**Wellington North Solar Farm (SSD-8895)
Request for Additional Information**

I refer to Assessment for the Wellington North Solar Farm (SSD-8895). After careful consideration, the Department is requesting that you provide additional information.

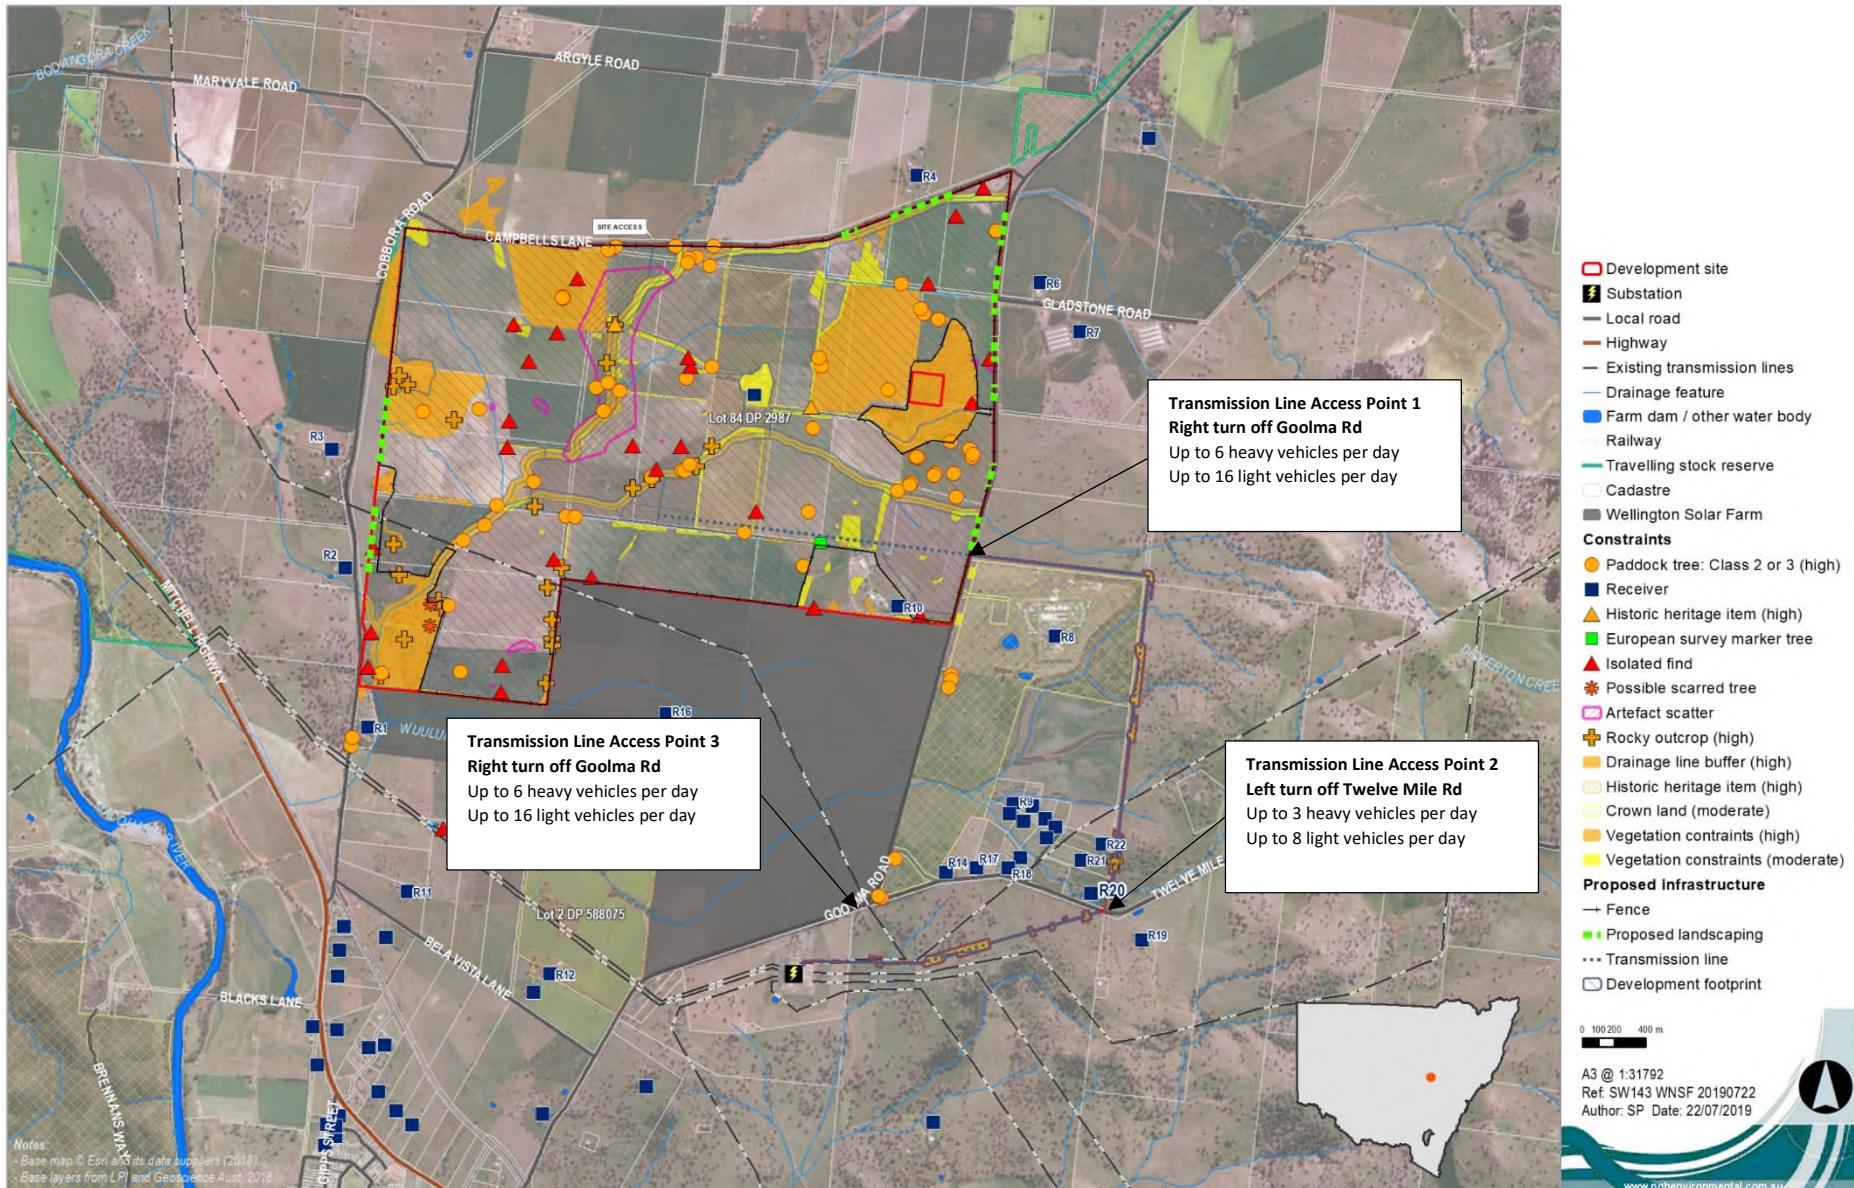
- Please confirm:
 - the traffic volumes likely to be generated during operation of the project;
 - the number of over-sized vehicles that would be generated during construction;
 - whether any traffic associated with construction of the transmission line would be required to use Twelve Mile Road and the intersection of Goolma Road/Twelve Mile Road;
 - the site access points for vehicles associated with construction of the transmission line; and
 - whether cumulative impacts of construction traffic on the intersection of Mitchell Highway/Goolma Road has been considered.
- Provide an updated figure showing the amended transport route and site access.
